Application: SSI 7485

I write regarding the proposed modification to M4-M5 Link, Mod 2 The Crescent overpass and changes to pedestrian infrastructure in North Annandale, Rozelle and Rozelle Bay Foreshore area.

Figure 4-2 Pedestrian and cyclist bridge infrastructure options

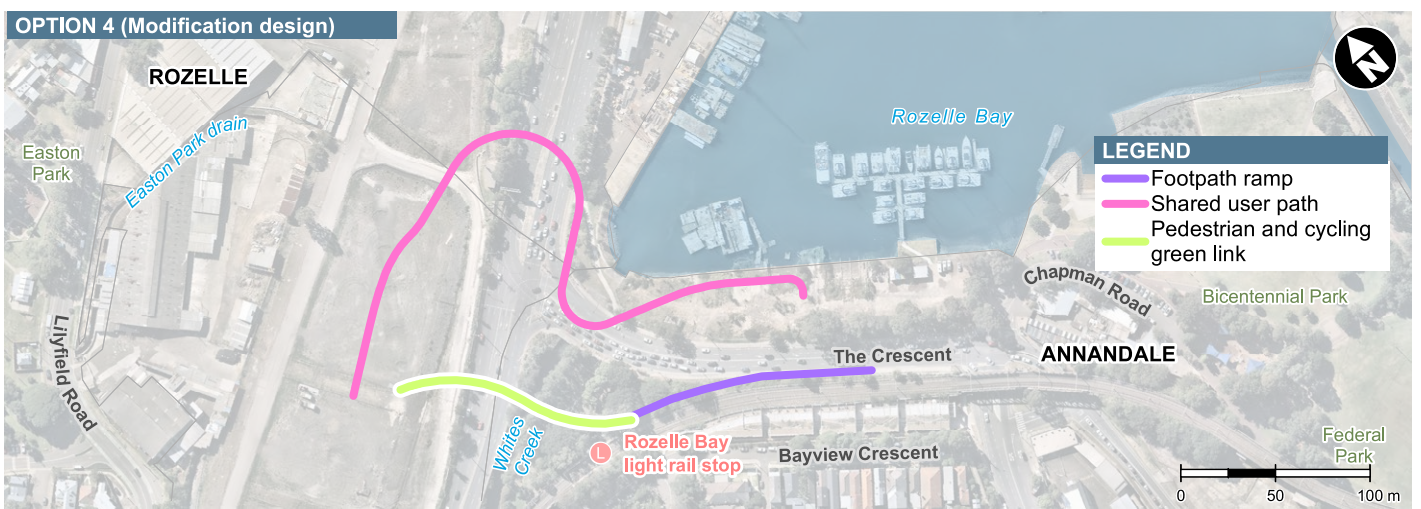
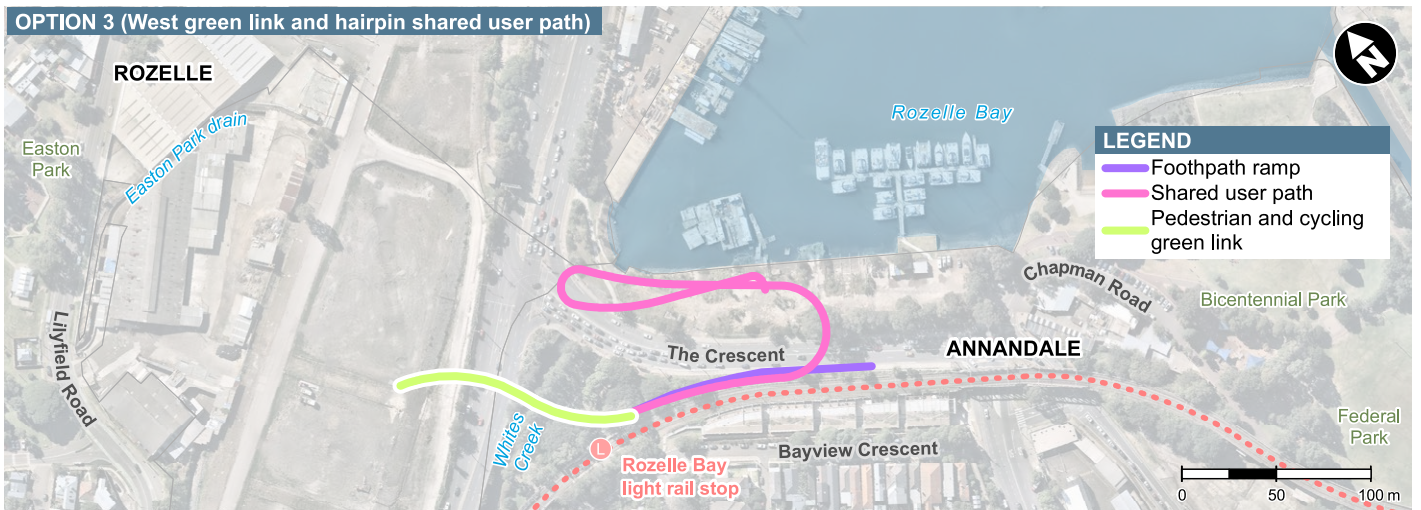
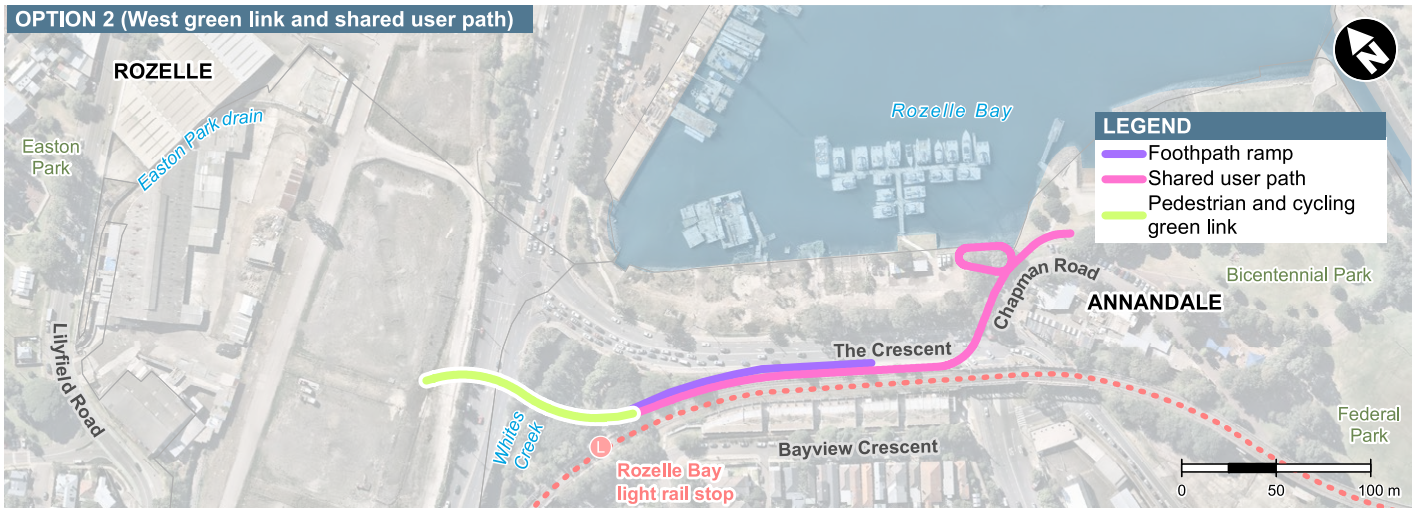
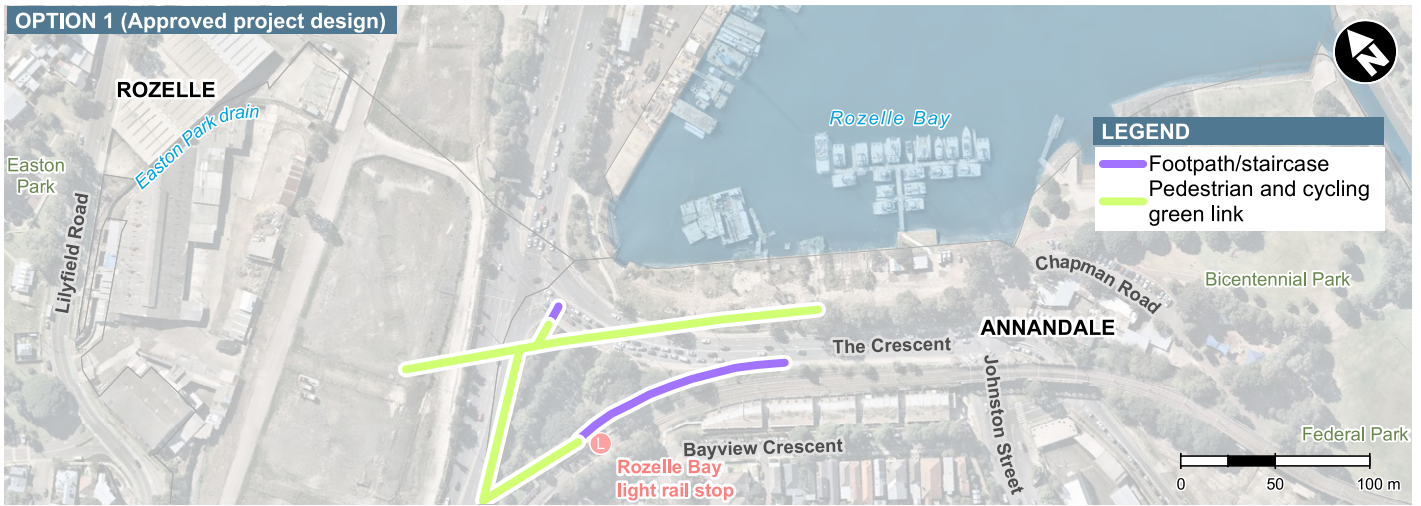
I request RMS work with the community to explore alternate design options to the proposed new car overpass design and the changed pedestrian and cyclist links. I am seeking the reinstatement of the safe, direct access from the approved EIS GreenLink to create a continuous green open space connection from the Rozelle Rail yards and Annandale to the foreshore. The GreenLink was more than just a walk way - it put people central to the design, maximising safety, and providing much needed accessible open space for the community now and into the future Bays Precinct design.

- Reinstate the GreenLink connecting communities and green open space from Rozelle to Bicentennial Park
- Relocate and design pedestrian and cyclist connections that are continuous, safe and direct.
- Design the modification infrastructure and active links in response to the character of the suburbs, the location of the foreshore and it's potential future development.
- Provide pedestrian and cyclist paths that maximise people safety and do not force them onto busier streets, unsafe concrete plazas and caged walkways.
- Integrate active and direct connections to all active transport - including the future Metro West and Foreshore Ferry Wharf

Figure 4-4 Elevation: Indicative view of The Crescent overpass

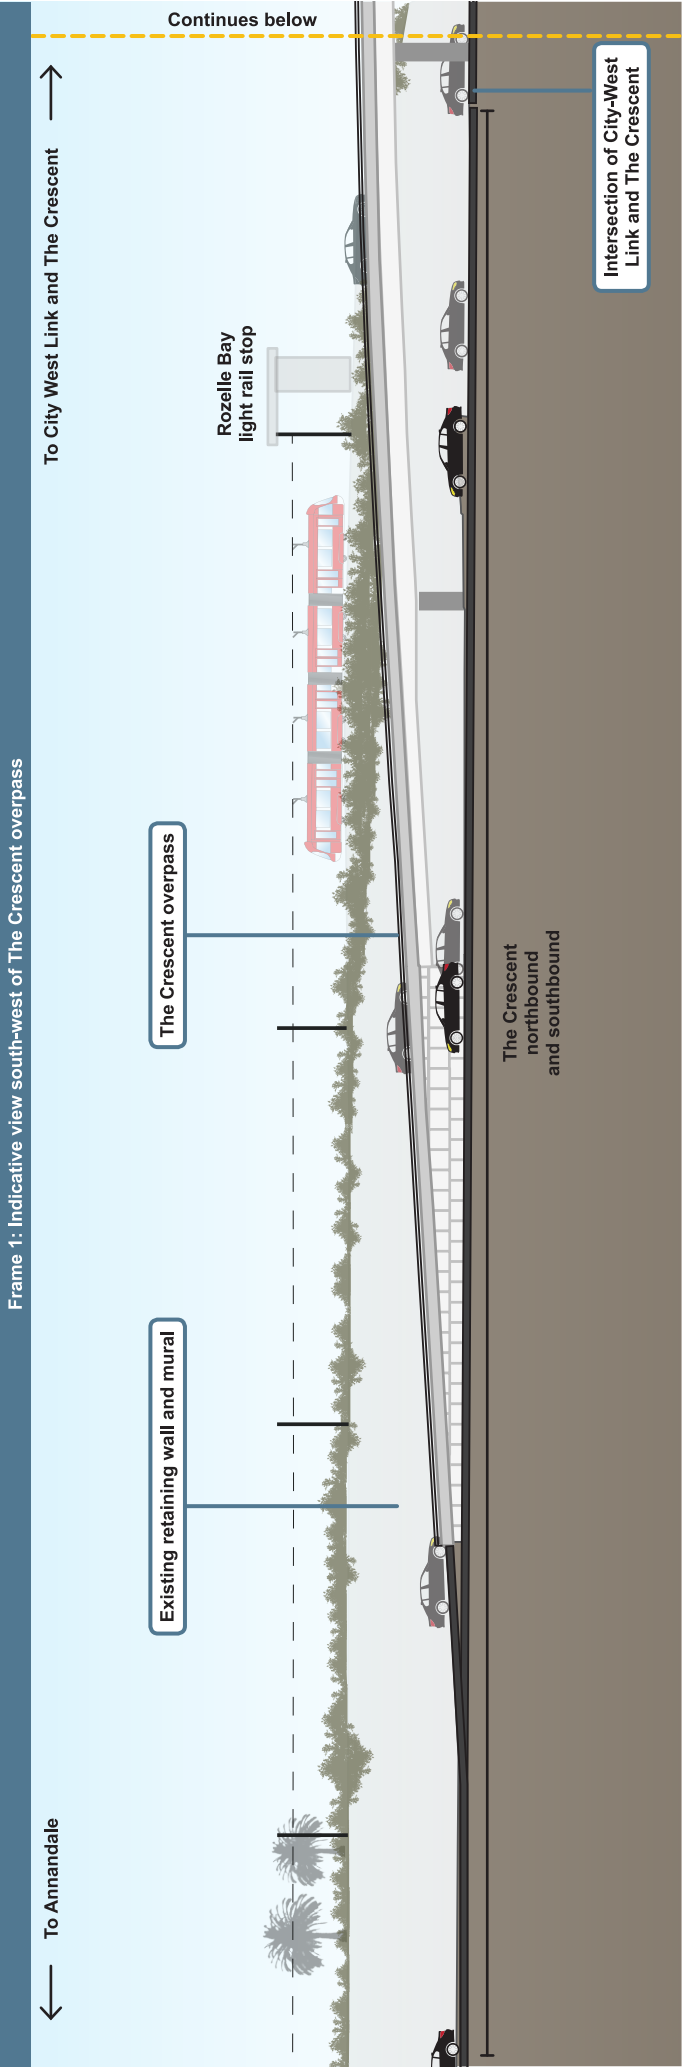
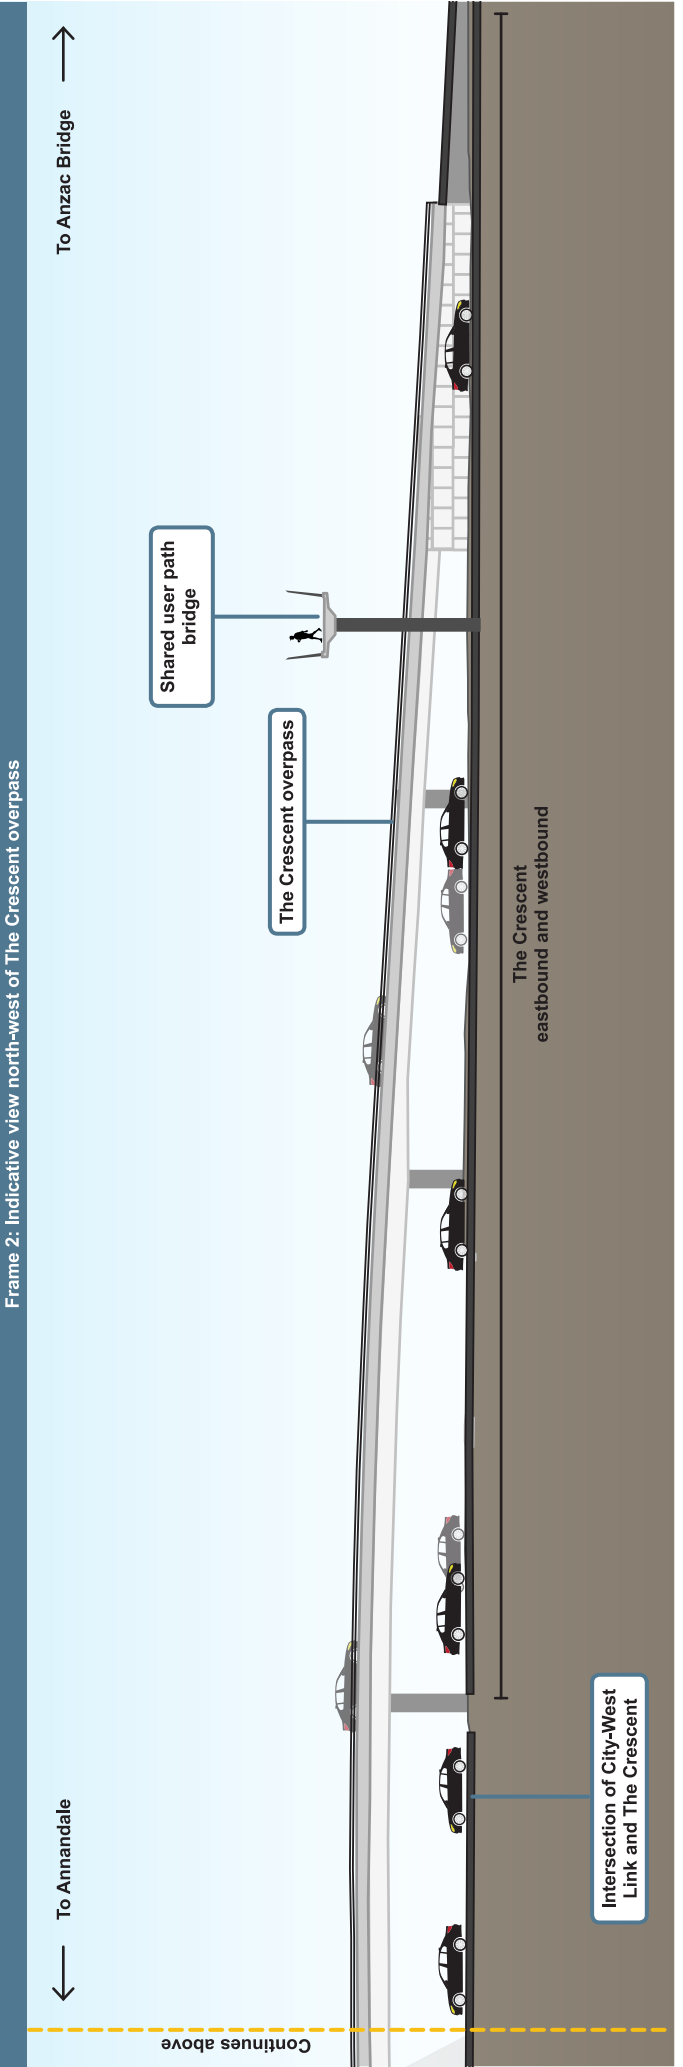
- The significantly reduced safety and increased risk for pedestrians and cyclists with removed access over The Crescent to Bicentennial Park and the increased traffic along Johnson Street.
- Being required to cross five sets of pedestrian lights at The Crescent as my option to reach the foreshore from Annandale or from Rozelle Bay light rail stop.
- Removal of direct active links to the foreshore, cutting the community off from the area and the proposed revitalisation of the entire Bays Precinct, including linking the Light Rail and Bus stops to a Ferry wharf and Metro station.
- Urban and landscape design that is being built before a finalised Masterplan for the area.
- Traffic changes that limit movements around the suburb and create further congestion in the local streets of Annandale, Forest Lodge, Glebe, Lilyfield and Rozelle with no planning to deal with these.

From what I have seen in a number of big cities around the world, car overpass like this proposed one is very bad for the community, segregating them into sections, increasing isolation, and increasing risks and danger spots.

I object this proposed car overpass. Please come up with an alternative that comply with the original approved design that put PEOPLE FIRST!
